Jeremy Bach
3410 Wilson Creek Road
Ellensburg, Wa 98926

I am adding these comments to the record regarding the 3BR custom cuts slaughterhouse/feedlot project, which is being proposed again in a residential neighborhood on Wilson Creek Road.

COMMENTS ON (REVISED) SEPA APPLICATION

DATE: November 20, 2023      SHEET:

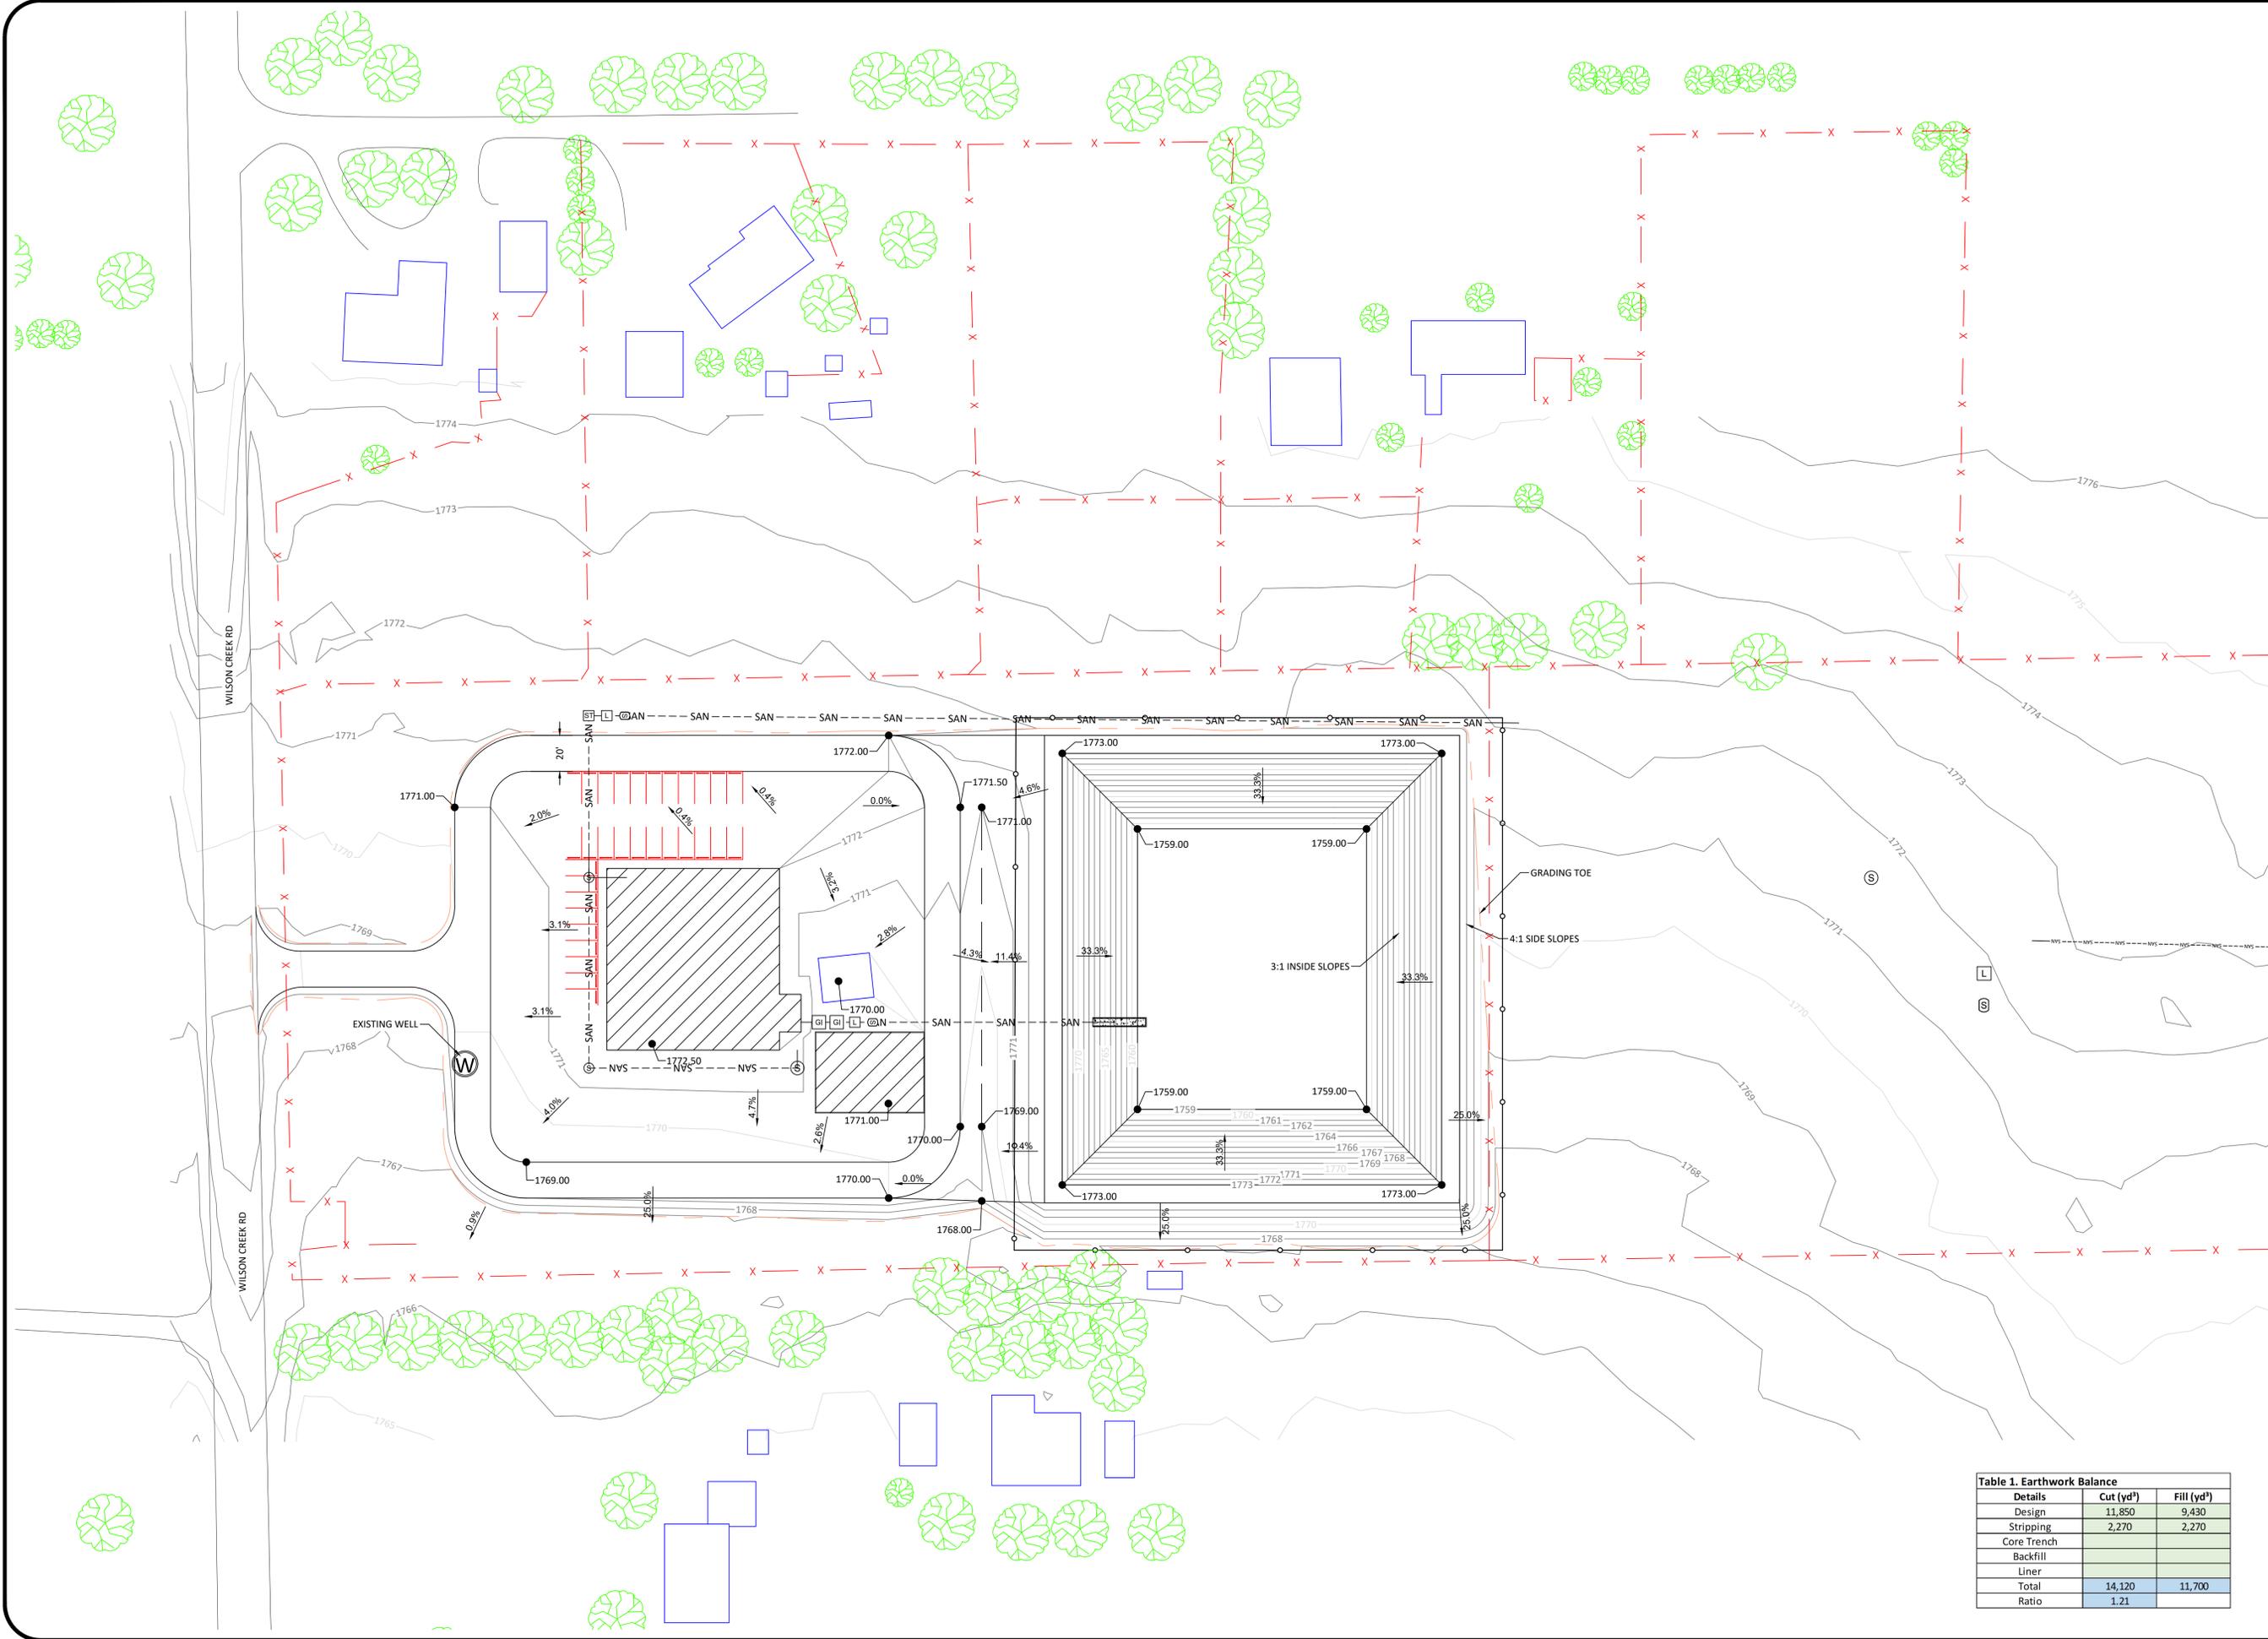
The current location of the existing well that would be used as a community well is located in or by the public access road as per the applicants' drawings submitted for comment on November 29, 2023.

Community wells need to have a 100ft radius in all directions as a sanitary area, this existing well does not, it is also located in an area that floods every spring as documented in my public comments from May 24, 2023.

The current site plan has the holding pens and facilities up gradient from the existing community well and flood area which are directly located within 150 ft of the Wilson Creek Road ditch.

Per the drawings, on November 29, 2023, it shows a 30-lot parking area. This parking lot is also located up gradient from the community well.

This large parking area is not even discussed in the SEPA application, and it does not outline how they are going to address the stormwater runoff created from this 30-car parking lot.
